Recommendation Report for Lawful Development Certificate for a Proposed Use or Development**REF NO:** FP/202/21/CLP**LOCATION:** 18 Pennyfields
Felpham
PO22 6BN**PROPOSAL:** Lawful development certificate for the proposed demolition of existing lean-to outbuilding and erection of single storey side extension**DESCRIPTION OF APPLICATION**

Drawing P01 August 2021 Scale 1:100 @ A3
Proposed Drawing - Plans & Elevations

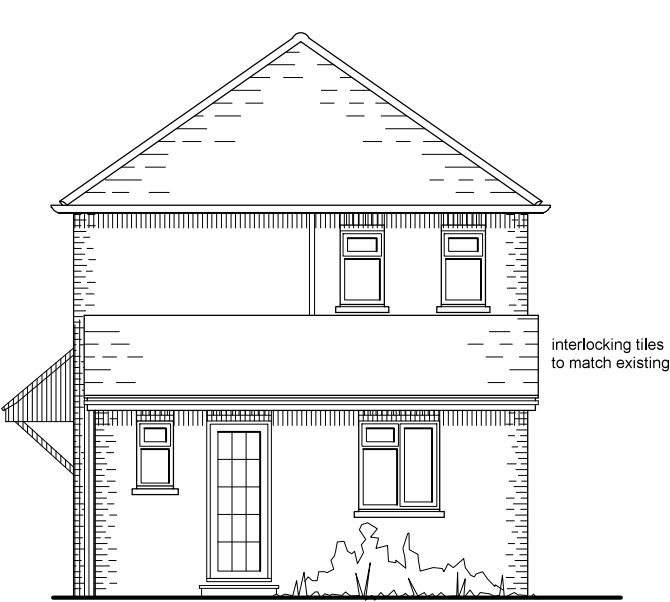
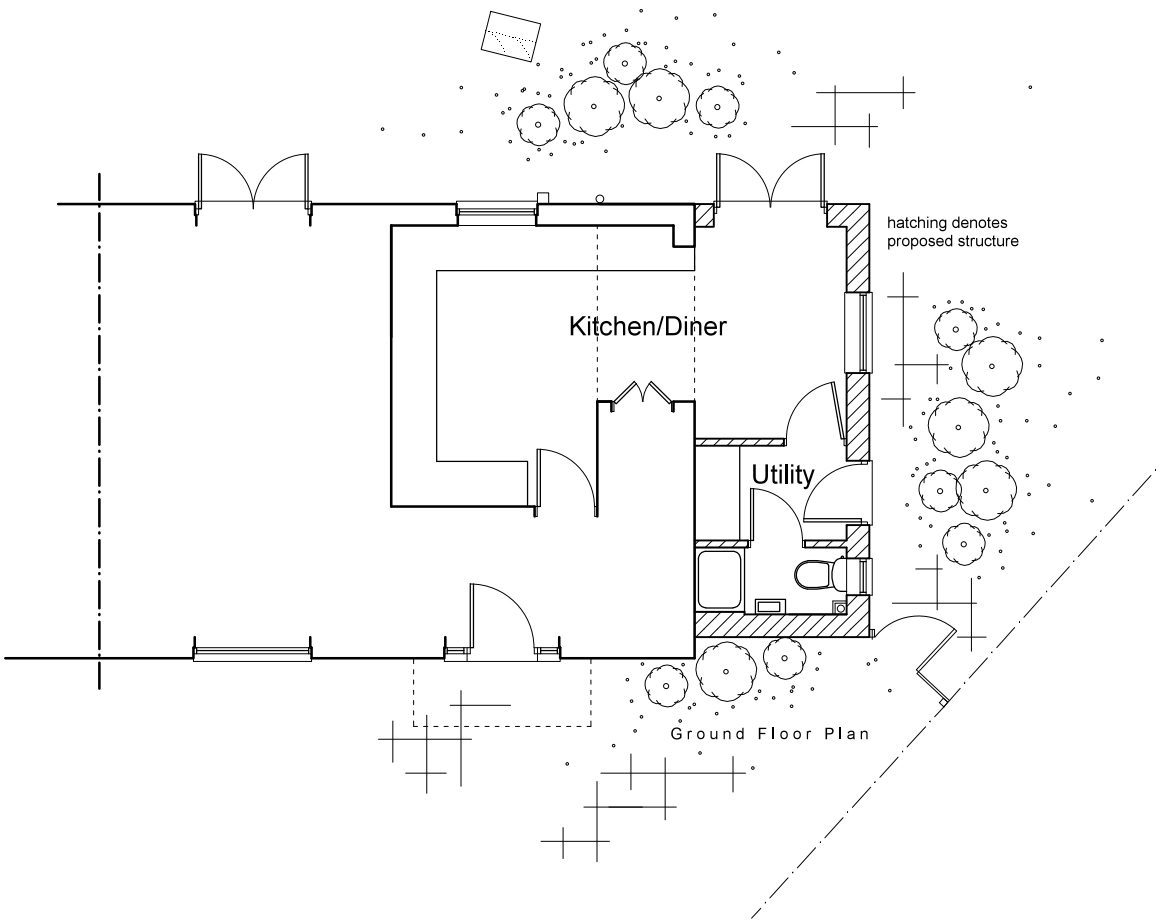
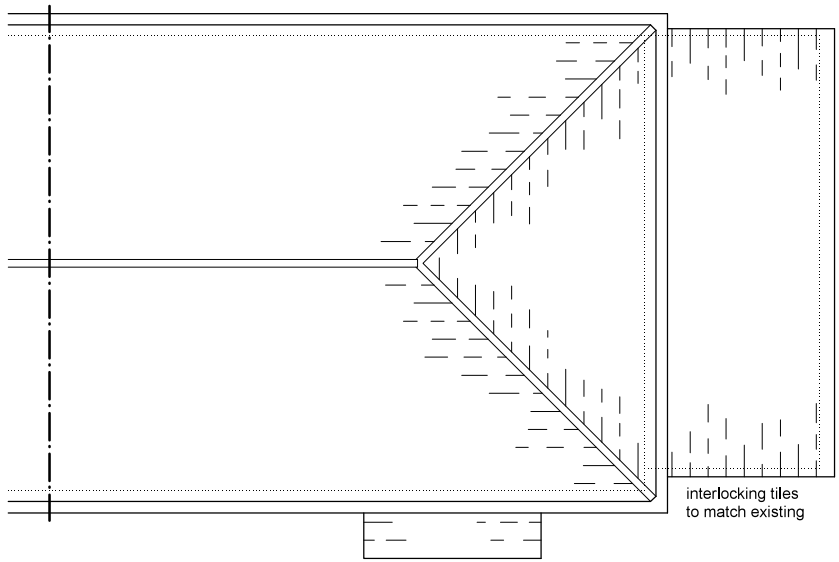
The proposed single storey side extension fails to comply with relevant section A1 (e) in that the enlarged part of the dwellinghouse would extend beyond a wall which - (ii) fronts a highway and forms a

side elevation of the original dwellinghouse.

The proposal is therefore not considered permitted development and as such requires the submission of an application for planning permission.
